2 February 2017

Our Reference: SYD16/00656/03 (A15938753)
DP&E Ref: SSD 7664

**PROPOSED HORSLEY DRIVE BUSINESS PARK – STAGE 2
COWPASTURE ROAD, WETHERILL PARK**

Project: 0300 Horsley Drive Business Park Stage 2
Drawing Title: Loading Dock Access Articulated Vehicle

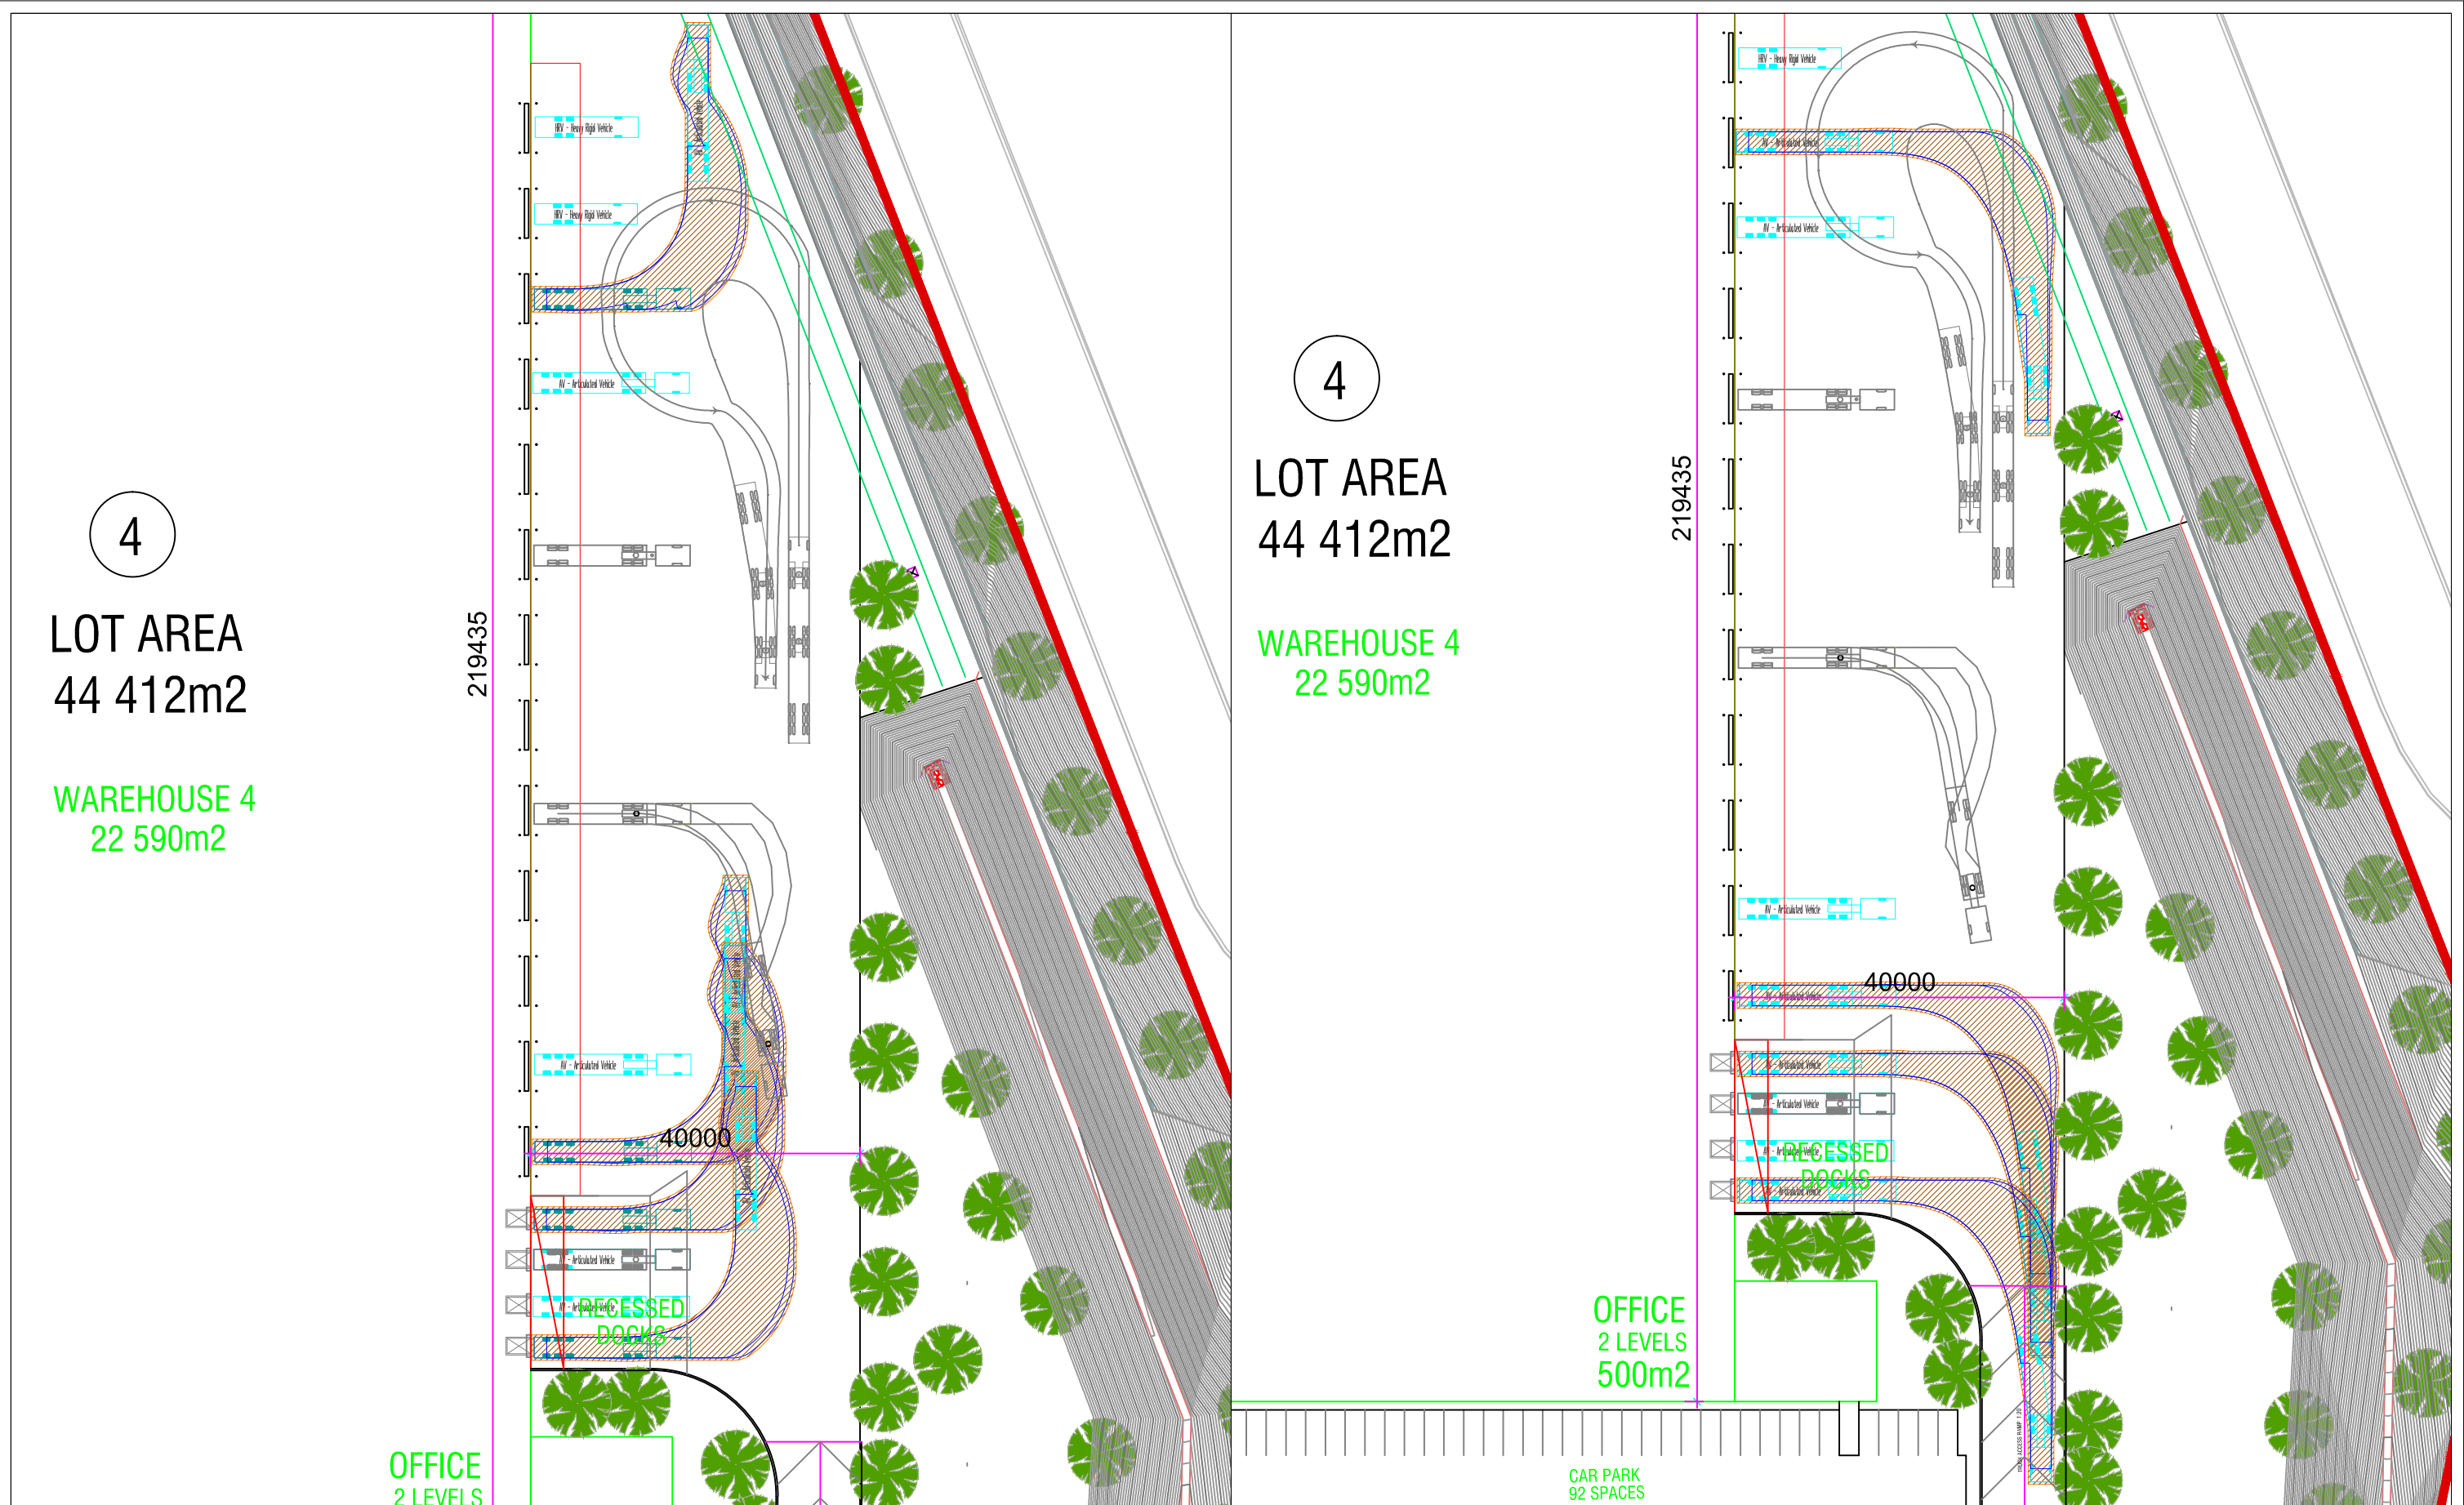
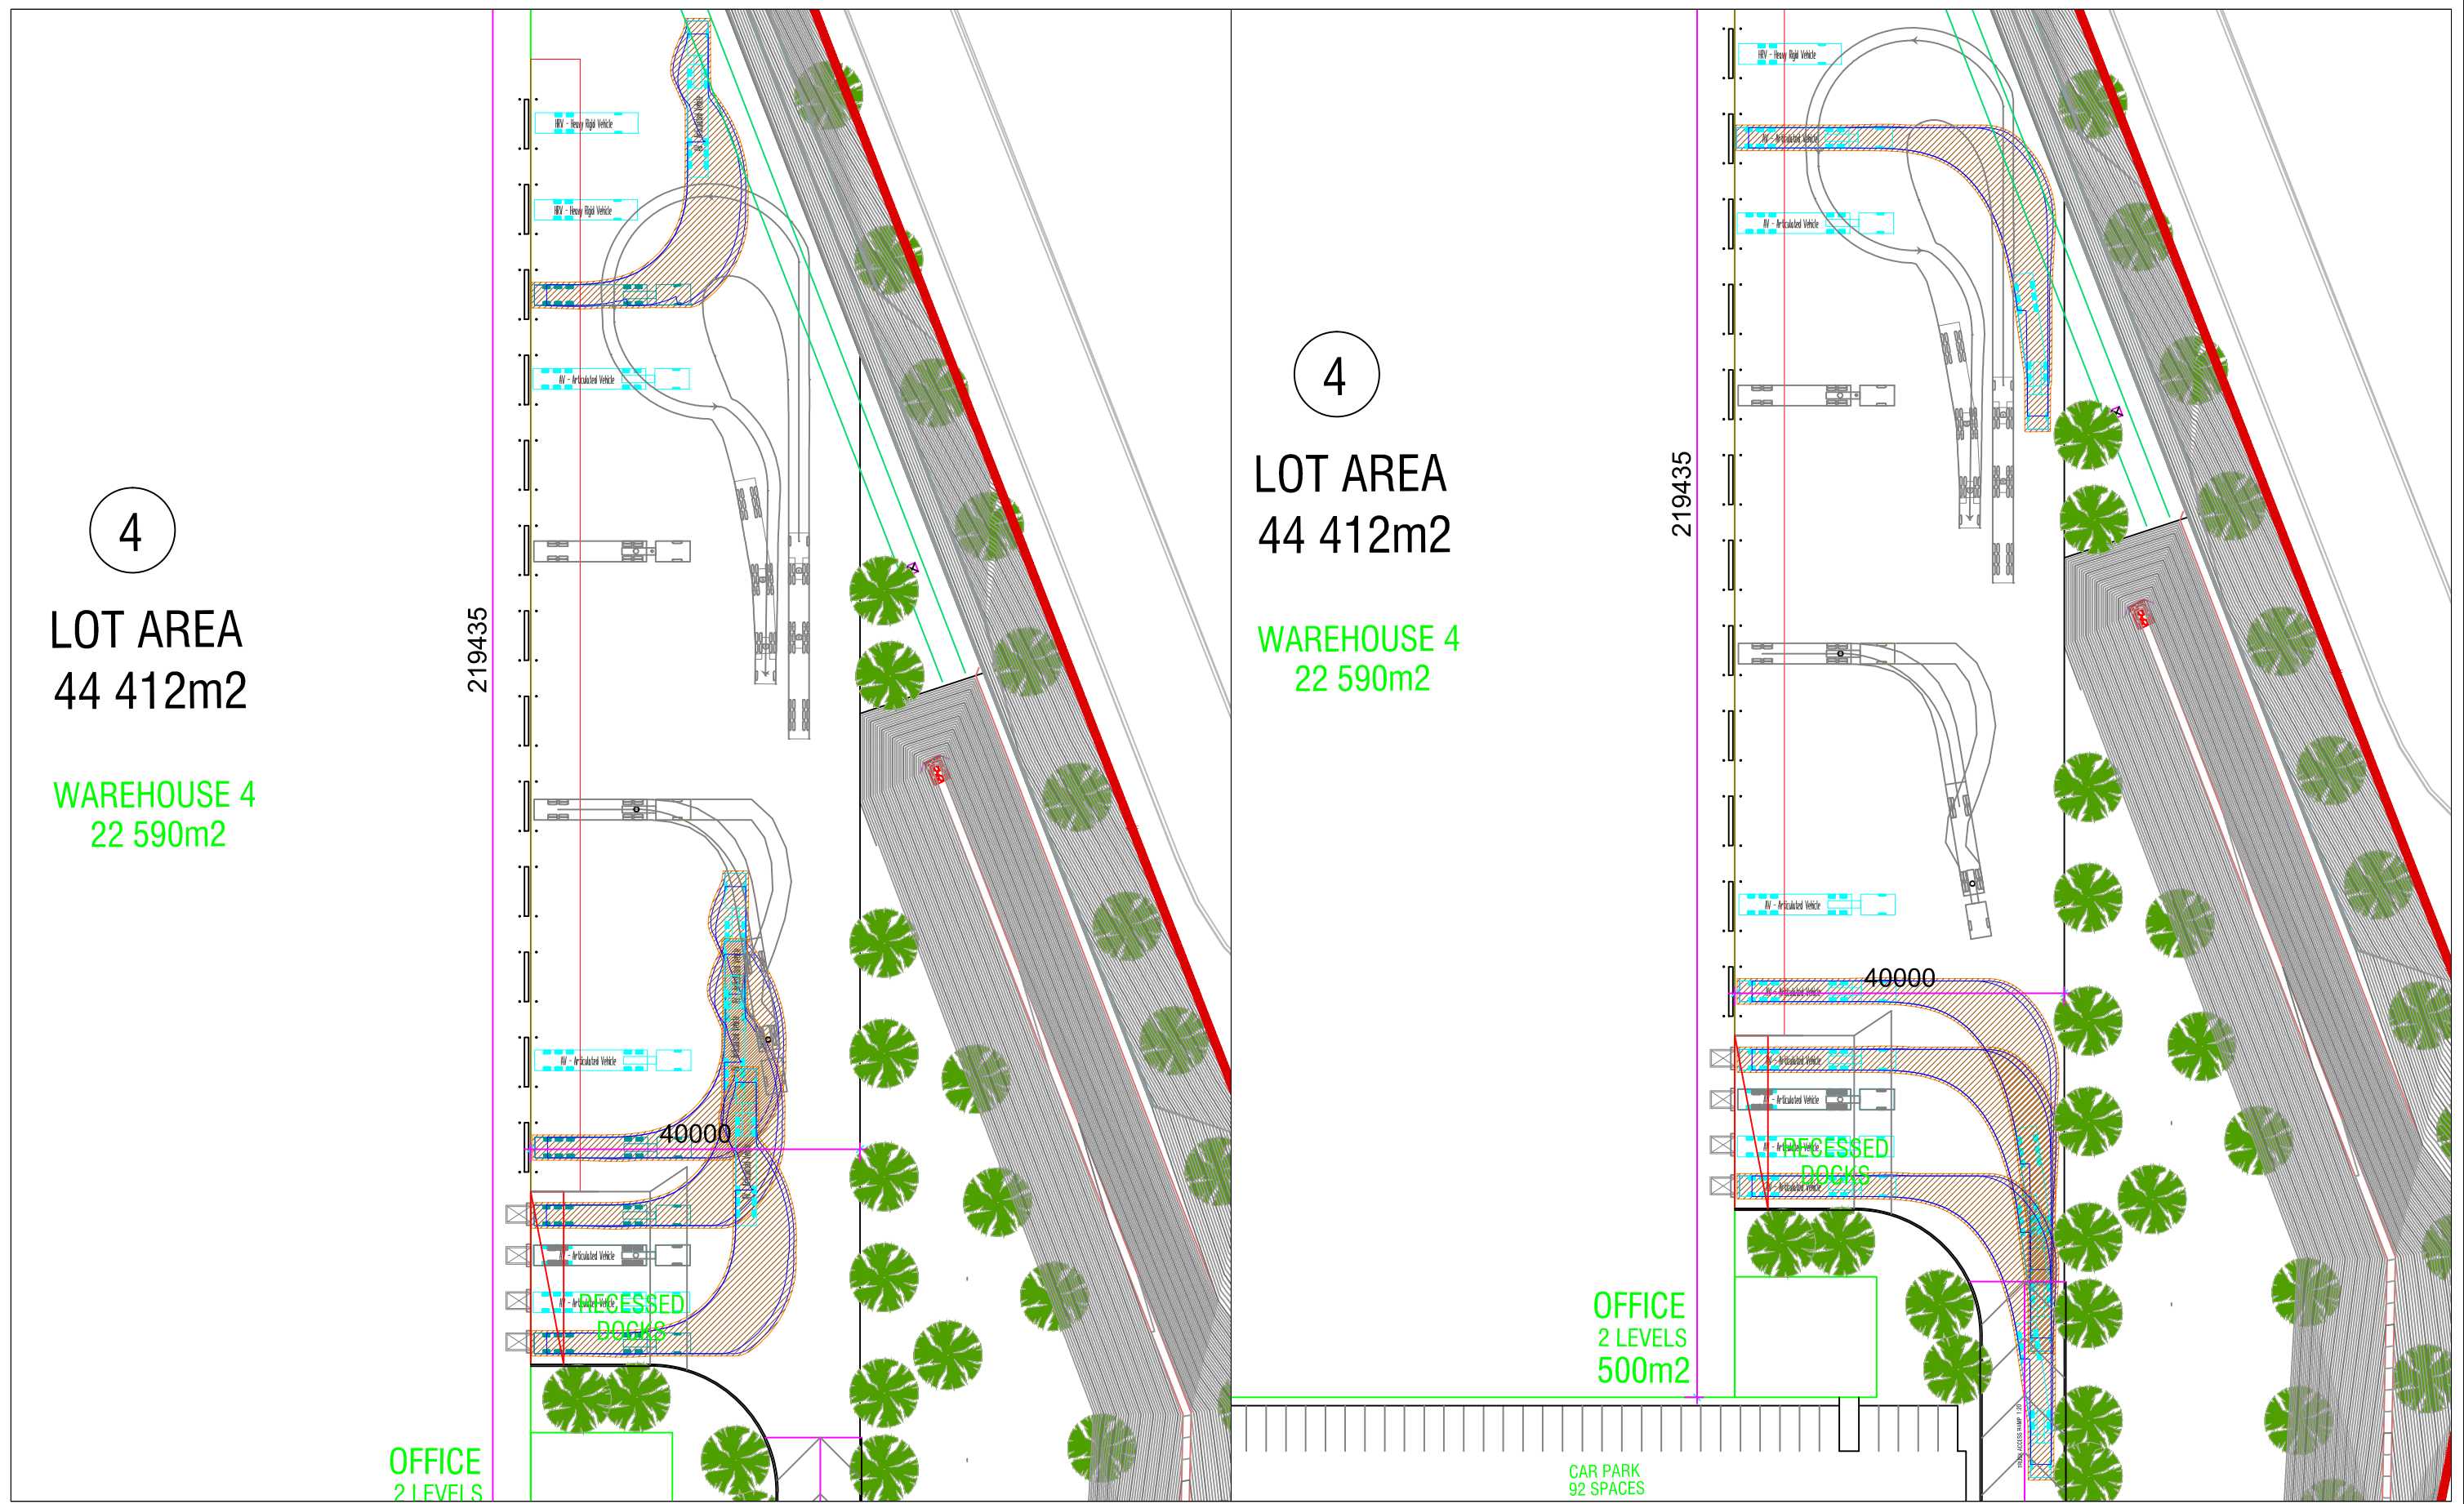
11. The swept path analysis provided for manoeuvring within the site shows the similar issues. Roads and Maritime recommends that sufficient manoeuvring space and clearance to be provided for heavy vehicle when entering and exiting the proposed driveways within the site.
